# ROYAL RANDWICK RACECOURSE SSD-10285 WINX STAND

Response to request for additional information  
June 2020

Prepared for  
**AUSTRALIAN TURF CLUB**  
18 June 2020

SSDA-301

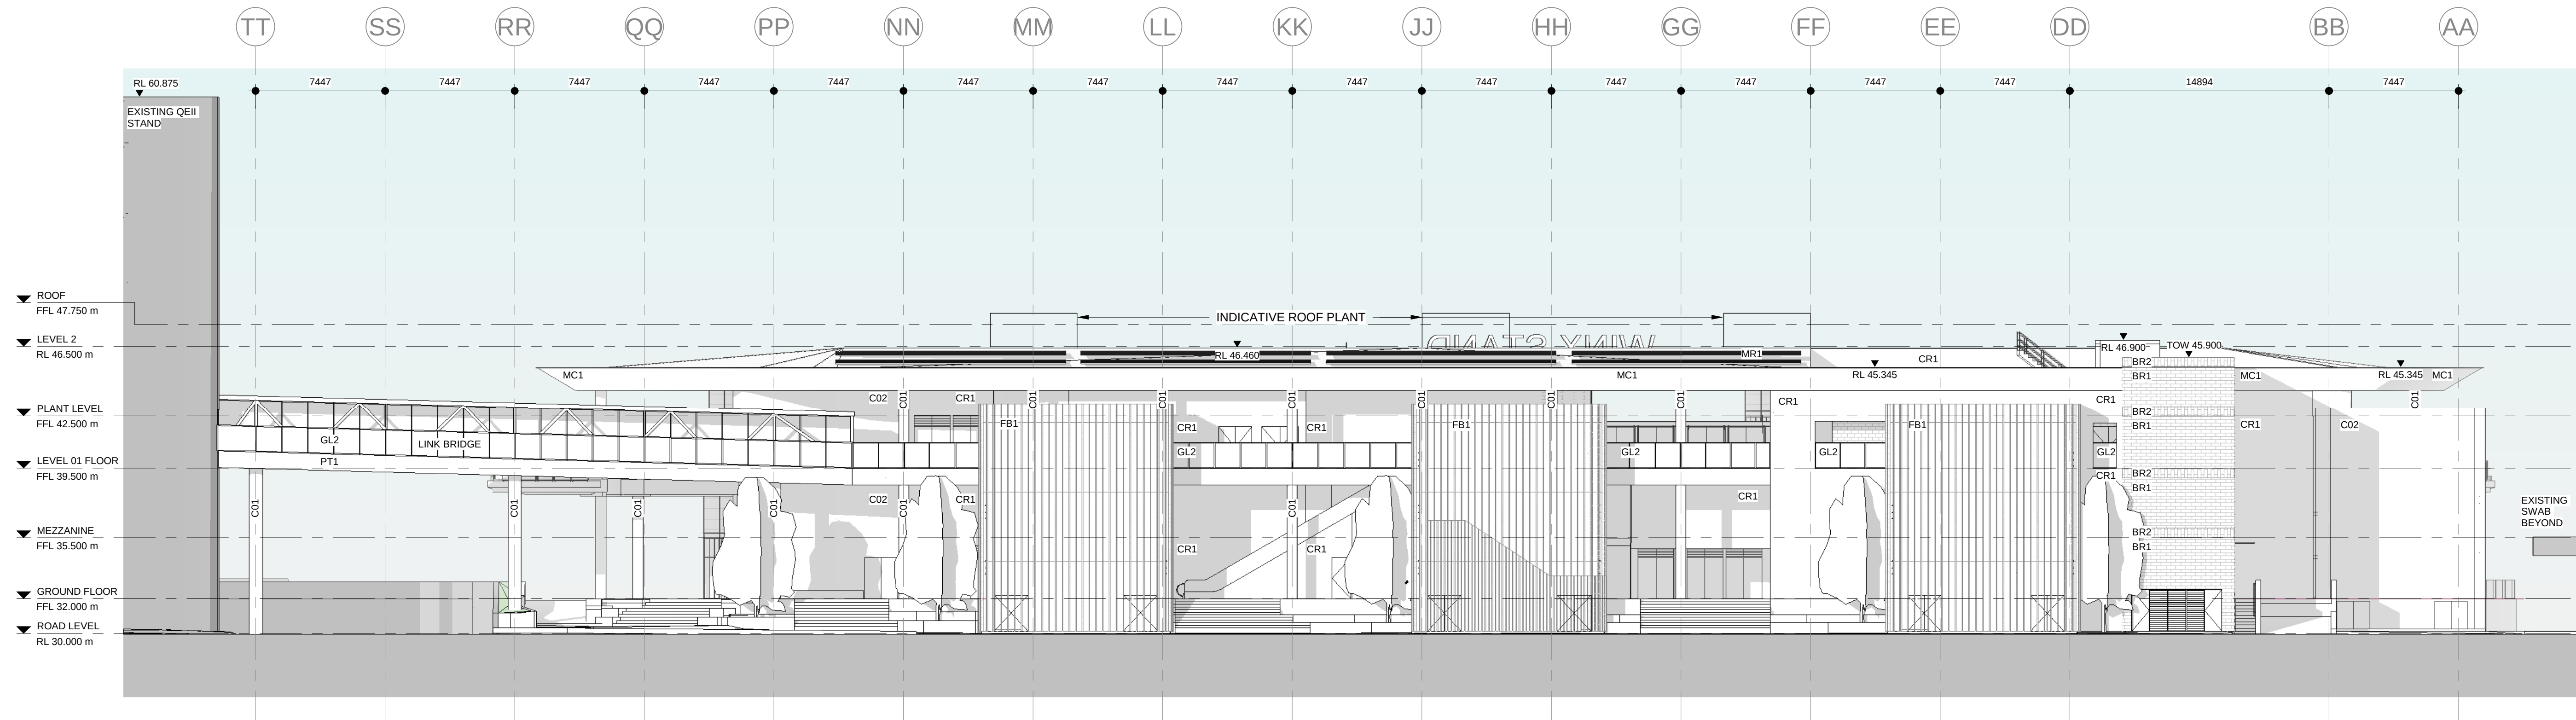
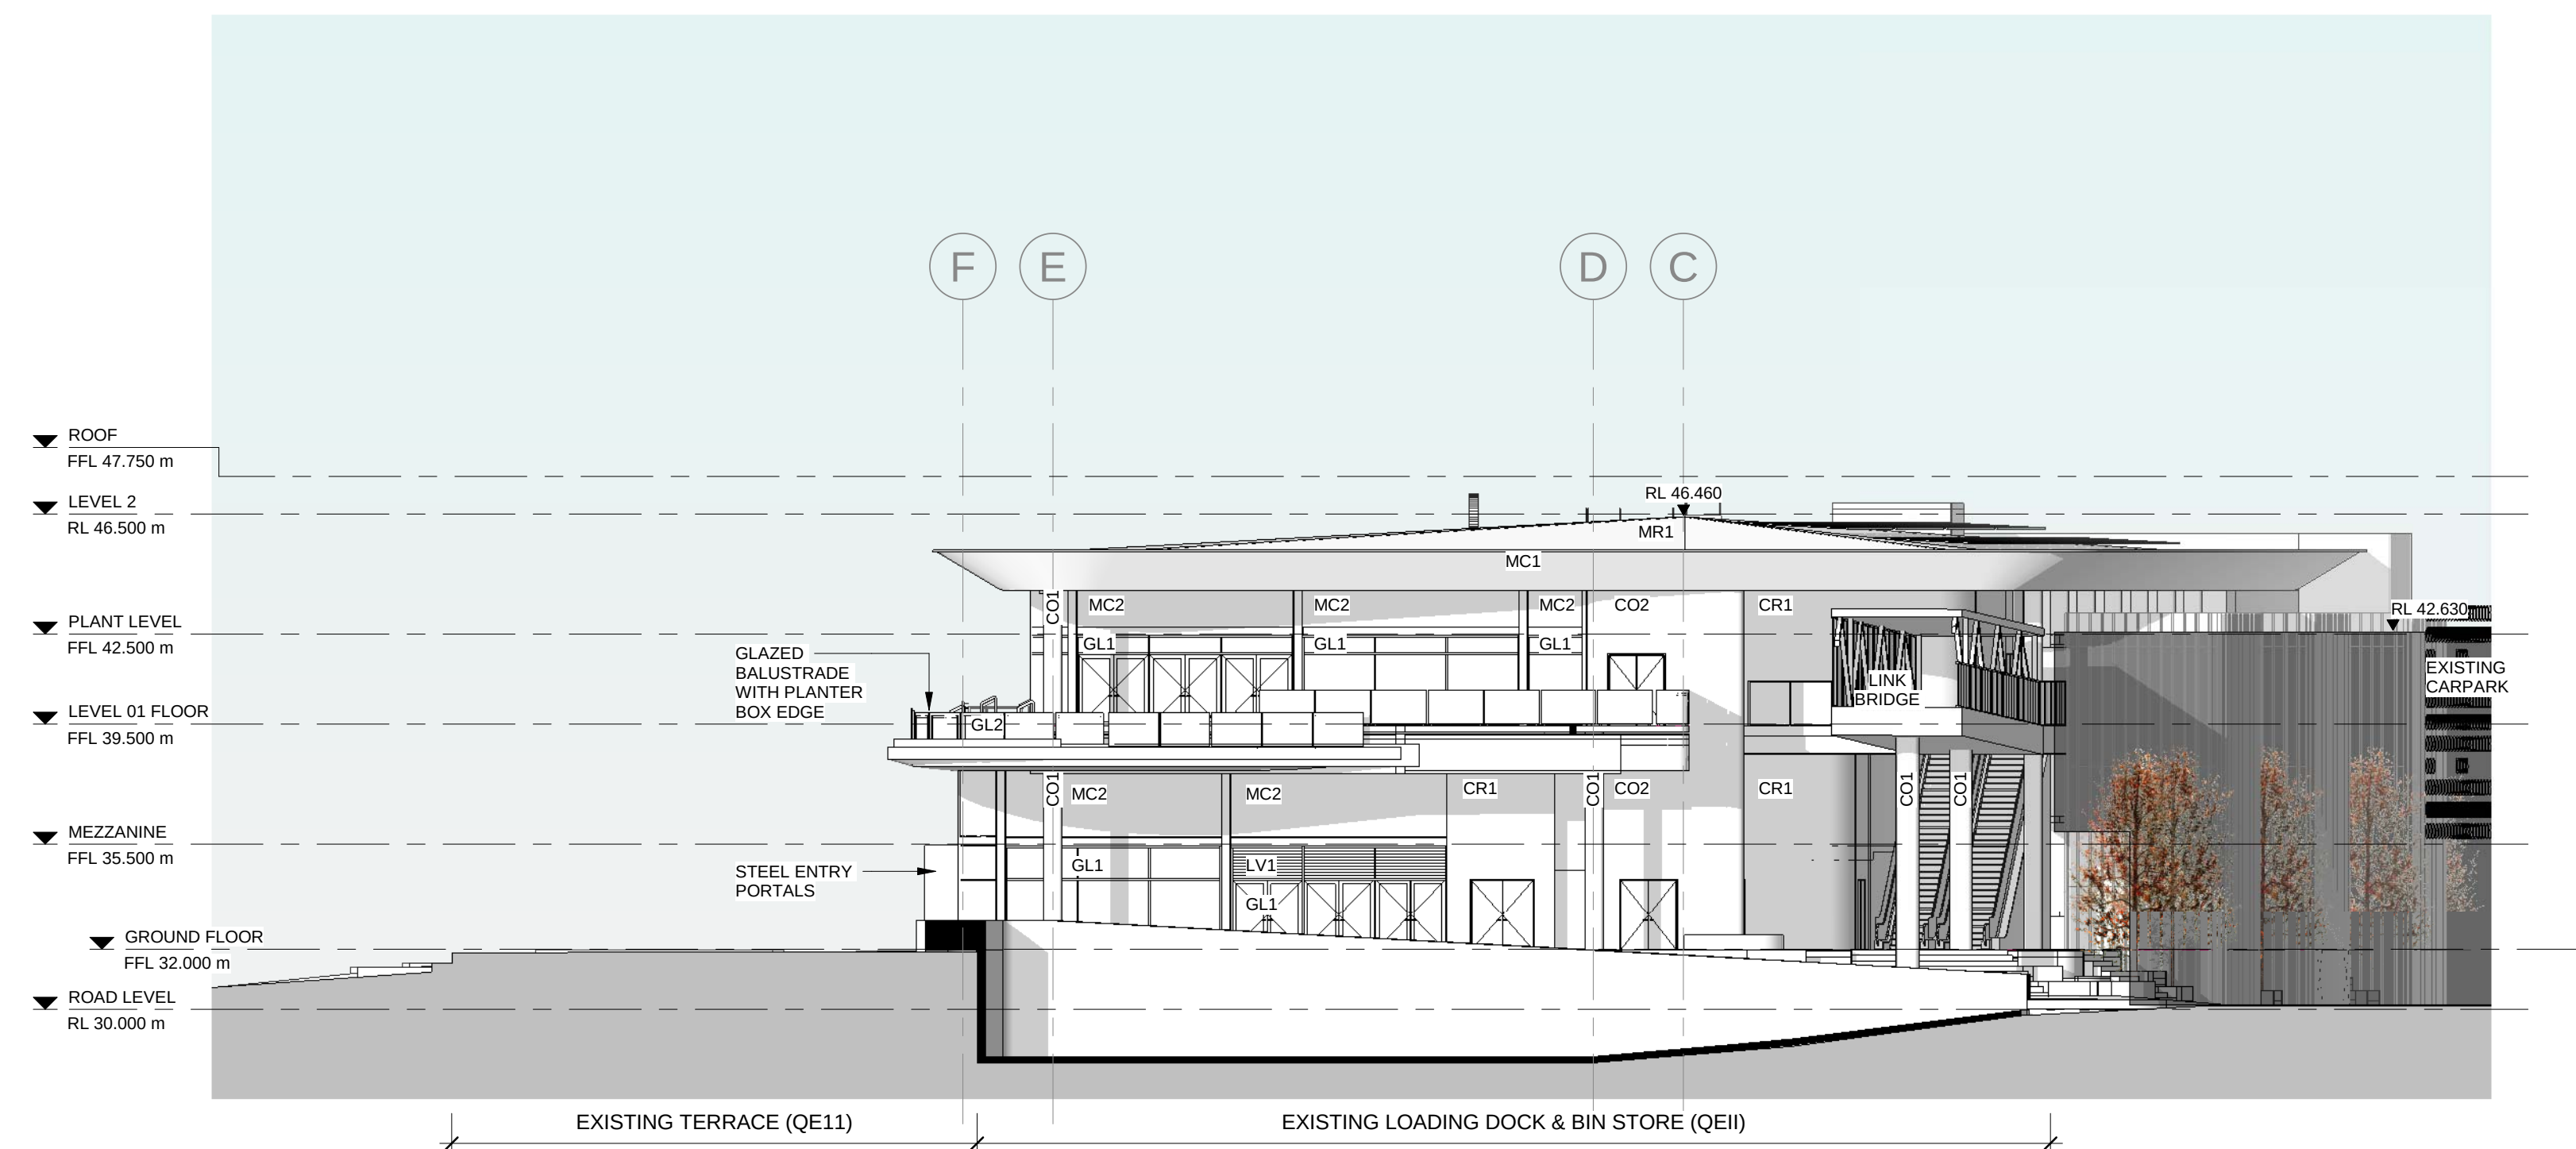
<p><b>BACK OF HOUSE FACILITIES</b></p> <p>In response to Council's earlier concerns regarding the visual impact of the back-of-house activities on the public domain, the Response to Submissions Report (Table 7, page 24) advises that:</p> <p><i>The back of house facilities are fully incorporated into the facility and are separated from general admission areas. The Winx Stand is fully located within the Spectator Precinct of Royal Randwick Racecourse and are not visible from the public domain</i></p>	Noted. The revised plans prepared by Cox Architects has been amended with an additional tree as requested. This can be seen SSDA-201-D and SSDA-301-C, in picture 11 on page 10 of this report and extracted below.

Issue	Referral Comment	RFI response/ action
	<p>Based on this advice, the Revised Architectural Plans indicates no additional screening measures in the laneway adjacent to the back-of-house area. It is recommend that to soften and screen the visual impact of this back of house area, including the loading dock, an additional tree should be provided on the south-western side of the stairwell adjacent to the sub-station at Grid DD in drawings No. SSDA-201 Revision C (Ground Floor) and No. SSDA-301 Revision B (North Elevation (Laneway)). This is indicated in the following montage.</p>  <p>Picture 12 Revised design (laneway looking north)</p> <p>Add new tree</p>	
<p><u>Heritage</u></p>	<p>Council officers have reviewed the RtS report and revised Heritage Archaeology Assessment (HAA). It is considered that the summary of submissions table satisfactorily addresses heritage issues raised by Council in its submission on the EIS. Council notes that the revised HAA makes recommendations in relation to a Chance Find Procedure in the event of uncovering archaeological resources. In relation to this recommendation, the following amended condition should be included:</p> <p>In the event of uncovering any archaeological resources including relics, the following Chance Find Procedure must be implemented:</p> <ul style="list-style-type: none"> <li>• Stop work and demarcate affected area.</li> <li>• Contact a suitably qualified archaeologist or heritage consultant to provide advice and assess the finds.</li> <li>• Notify the Heritage Council of NSW under Section 146 of the NSW Heritage Act 1977 if the finds are assessed as relics under the NSW Heritage Act 1977.</li> <li>• Provide an appropriate archaeological management plan to manage the identified relics.</li> </ul>	<p>Noted. No further action required.</p>
